**Recommendation:** Refusal

**Proposal:** Discharge of Condition 4 (amended materials plan) of 18/01309/REM

OXFORD ROAD, BODICOTE – MATERIALS PLAN – PHASE 2

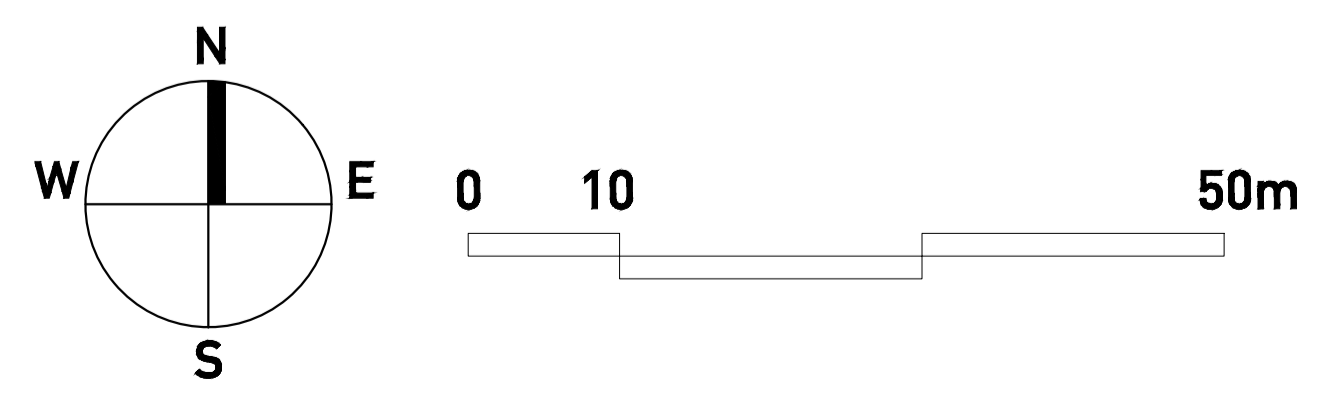
- 2.2. Covering letter (dated 15<sup>th</sup> December 2020) and materials plan P18-1568\_07 Rev. F (although revision not annotated on the drawing) are submitted in support of the application to discharge this condition.
- 2.3. It was noted that whilst the applicant's covering letter only referred to the changing of materials for plots 82, 83, 94 & 95, the submitted materials plan P18-1568\_07 also indicated plot 84 as being changed to brick; the agent subsequently confirmed that they were only proposing the semi-detached plots 82 and 83 on the north side of the road as brick (as well as plots 94 and 95 opposite) and not plot 84.

- 5.9. It is considered that the proposed greater proportion of brick built properties as set out within this application would materially diminish the quality of approved development, contrary to both national and local guidance detailed above. The proposed schedule of materials set out in this application would result in development that would fail to reflect and reinforce local distinctiveness and character, and would create an unsatisfactory appearance for the completed residential development in this edge of rural village location, and is not justified in this instance.

The proposed materials plan does not demonstrate an appropriate mix of construction finish materials across the development as a whole to ensure that the proposals would reflect and reinforce local distinctiveness and character and create a satisfactory appearance for the residential development in this edge of rural village location. The proposals are considered contrary to the provisions and aims of saved Policies C28 and C30 of the Cherwell Local Plan 1996, Policy ESD15 of the Cherwell Local Plan 2011-2031 Part 1 and guidance within the NPPF in respect of Achieving well-designed places.
